From: Ginger Weiser <gweiser@encompasses.net>
Sent: Tuesday, November 19, 2019 9:19 AM
To: Chelsea Benner
Cc: Marc Kirkpatrick
Subject: FW: LYTLE BLA BL-19-00016

From: Holly Erdman <Holly.erdman@co.kittitas.wa.us>
Sent: Monday, November 18, 2019 4:27 PM
To: Ginger Weiser <gweiser@encompasses.net>
Subject: RE: LYTLE BLA BL-19-00016

Subject: LYTLE BLA BL-19-00016

**RECORD OF SURVEY**  
 A PORTION OF THE W 1/2 OF THE SW 1/4 OF SECTION 3,  
 TOWNSHIP 19 NORTH, RANGE 14 EAST, W.M., KITTITAS COUNTY, WASHINGTON

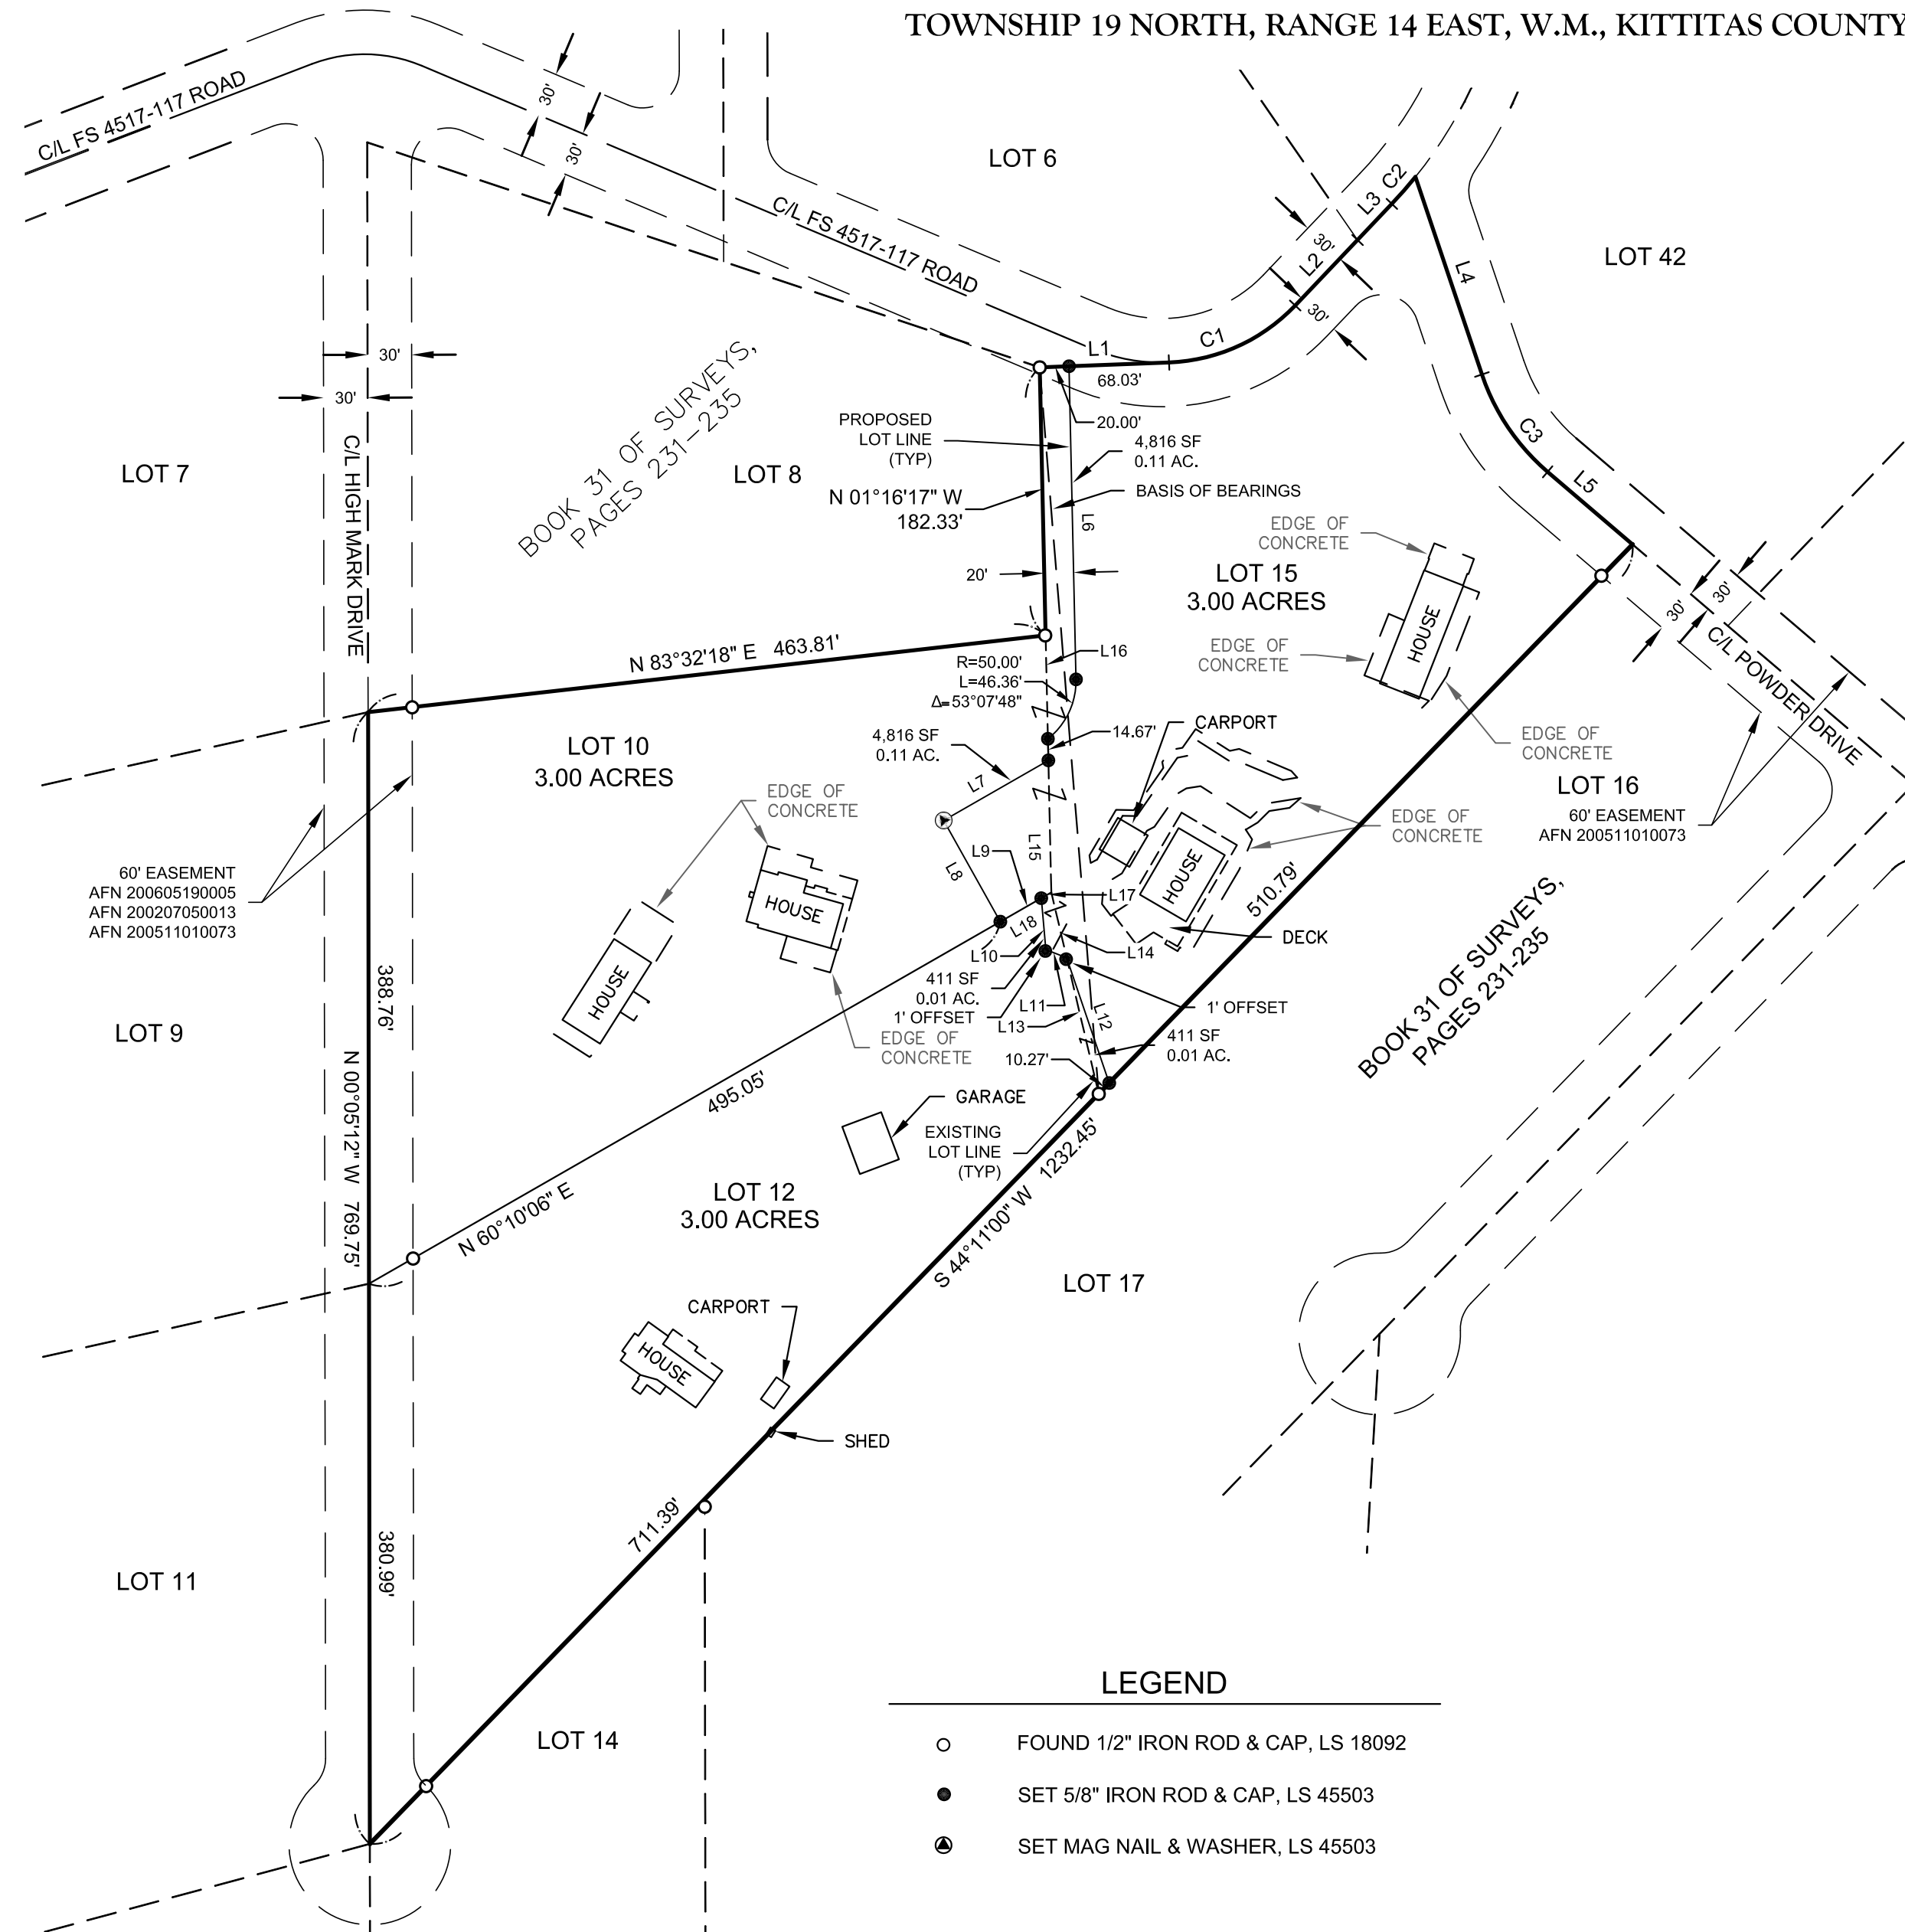
Thank you for that information. I just need to know where the replacement drainfield will be located and how far the closest leg of that replacement drainfield will be from the proposed boundary line. There always has to be adequate space for 100% replacement of a drainfield.

I have reviewed the locations of the wells for the 3 lots involved in the BLA and the well locations are not going to be an issue with the proposal. However, I have a concern that the proposed addition to lot 15 appears to be getting close enough to the existing drain field on lot 10. According to the septic system design, the drain field lines are on the same side of the house as the proposed boundary line for lot 15. The drawing shows the lines being 80 feet long and the reserve area is next to the existing drain field. Since the proposed boundary appears to be encroaching into the area of the primary and reserve drain fields it would be wise to have the lines located and measure to be sure the proposed boundary will not come within 5 feet of the closest leg of the existing drain field as well as the future reserve area.

I have attached a new pdf (1"=60') showing the reserve drainfield (replacement drainfield) with the dimensions from the property lines.
